**FINAL DRAINAGE REPORT
FOR
LATIGO TRAILS FILING NO. 10
AND
ADDENDUM TO MASTER DEVELOPMENT/
PRELIMINARY DRAINAGE PLAN
FOR LATIGO TRAILS,
EL PASO COUNTY, COLORADO**

September 2021

Add text:
PCD File No.:
SF2136

EXISTING POND SOUTH
OUTLET STRUCTURE PLAN
SCALE: 3/8"=1'

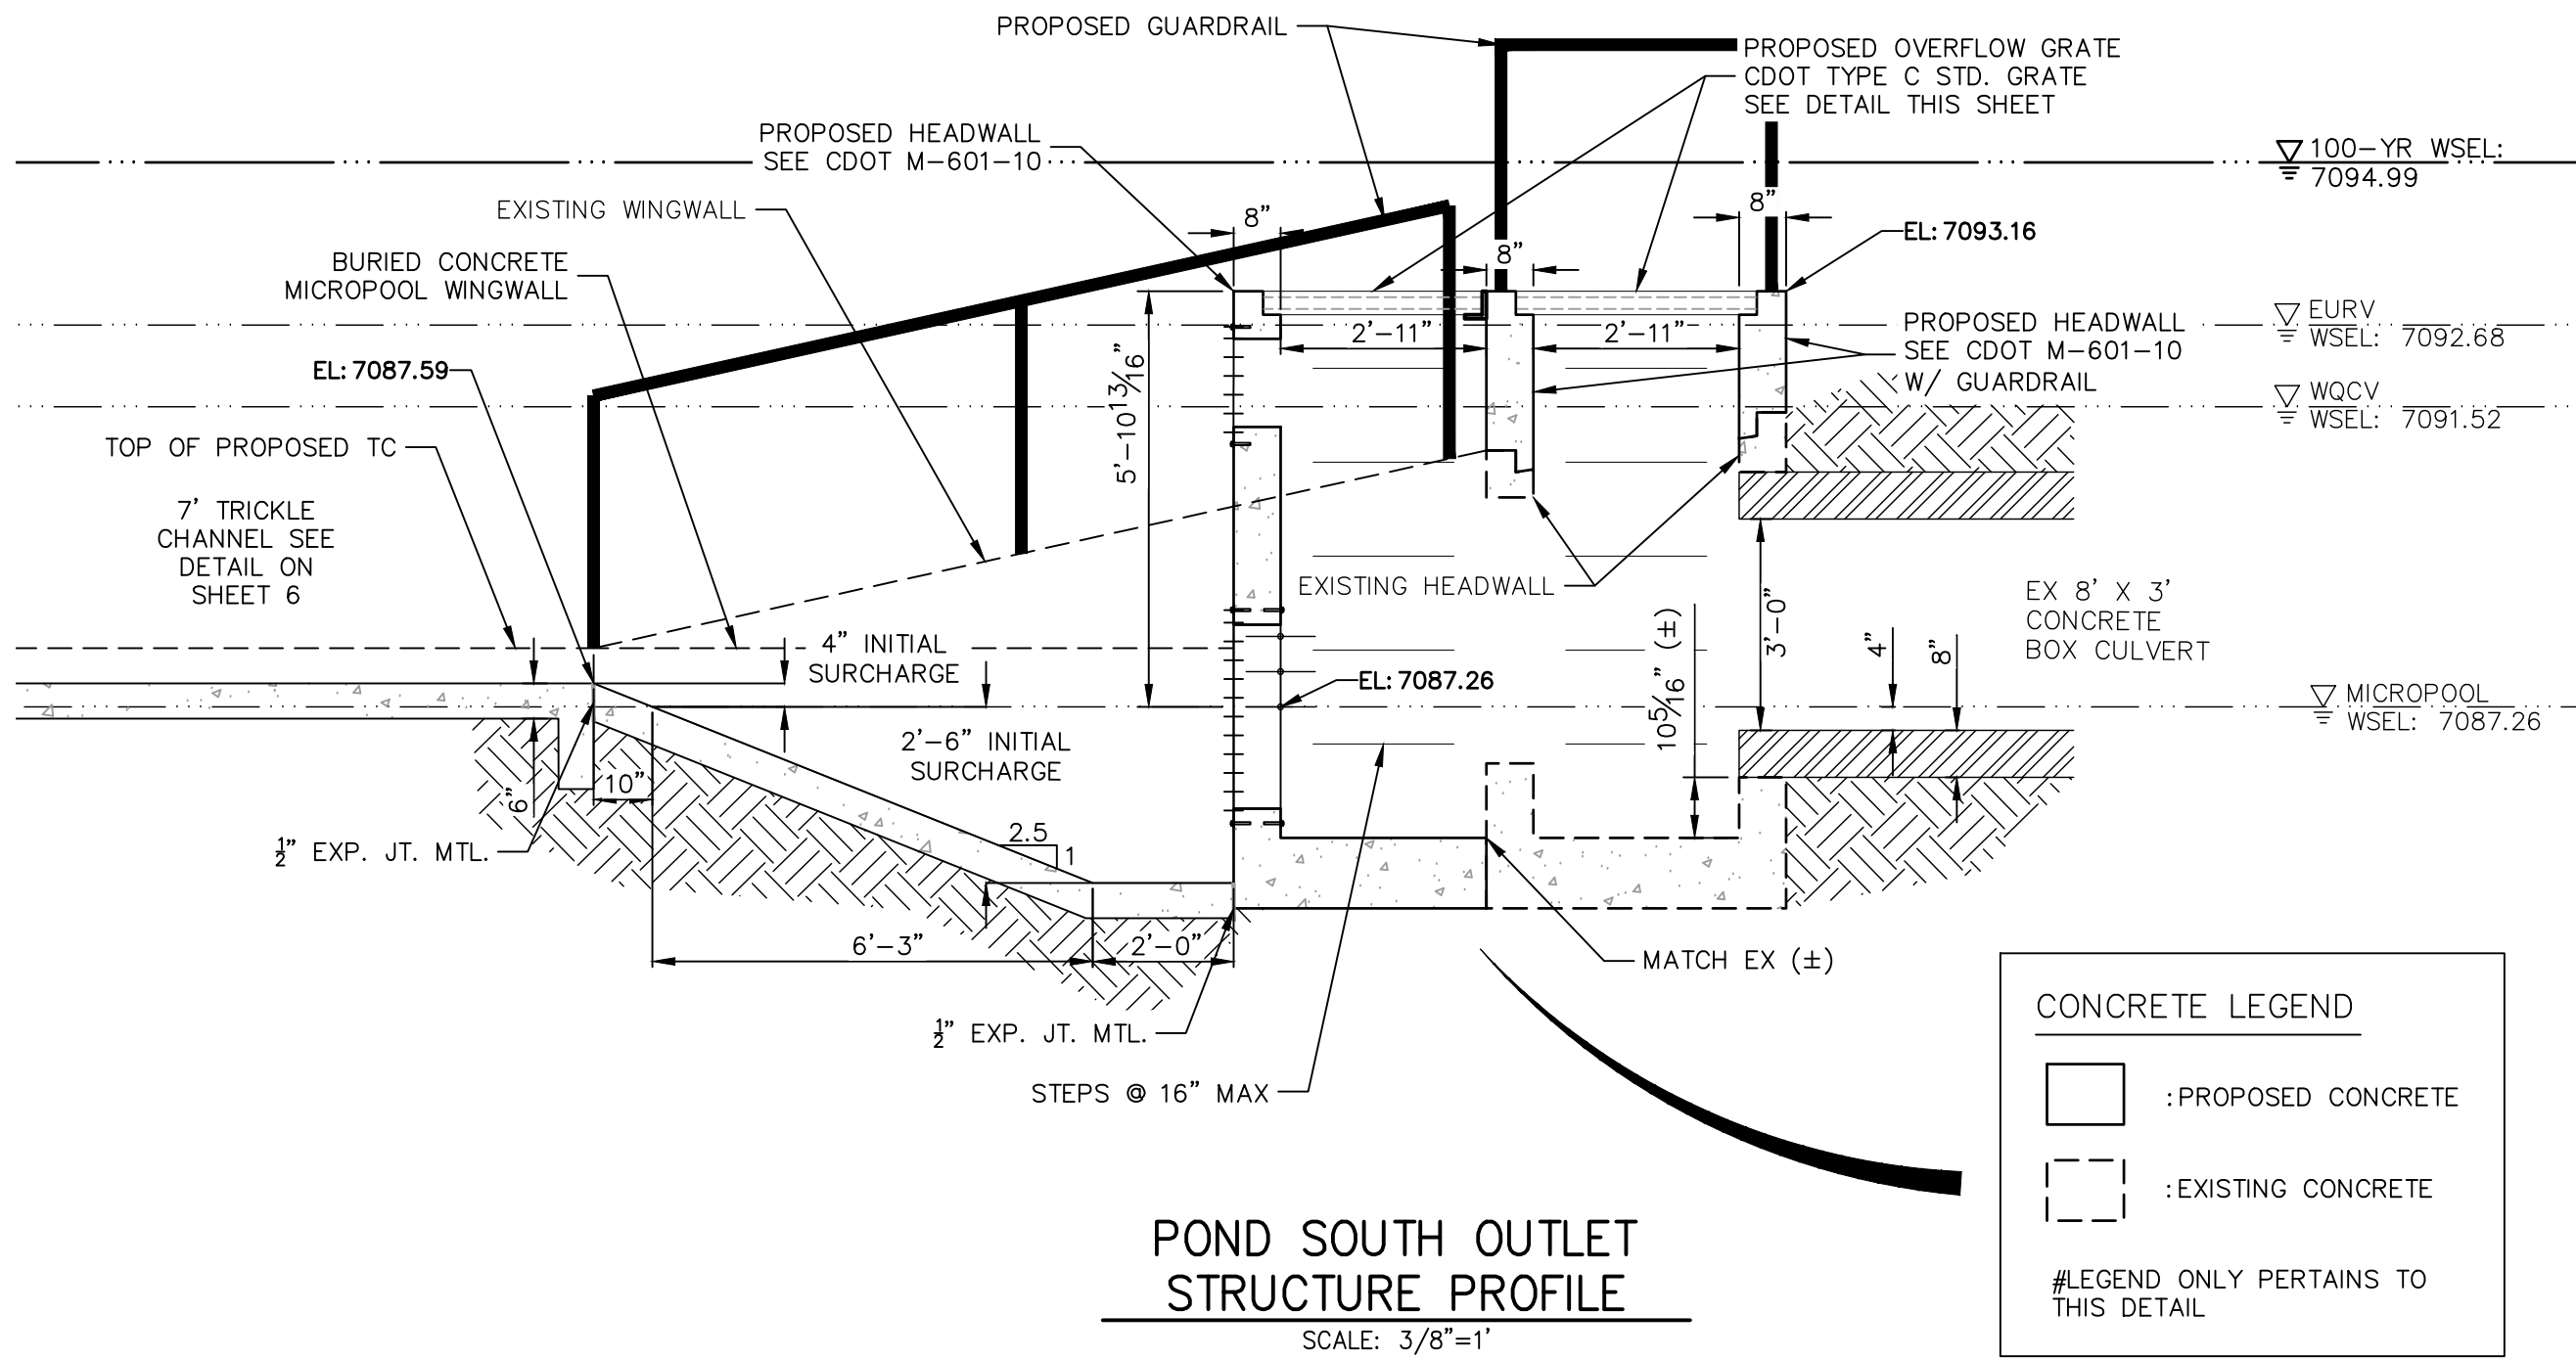
Clarify. Is the needed 10.3 ac-ft volume associated with the existing condition or w/ filing 10 development or ultimate condition (which includes Filing 12)?

The outfall needs to be analyzed with this FDR. Update last sentence to provide a summarize the results. Is the conveyance downstream of the pond hydraulically adequate?
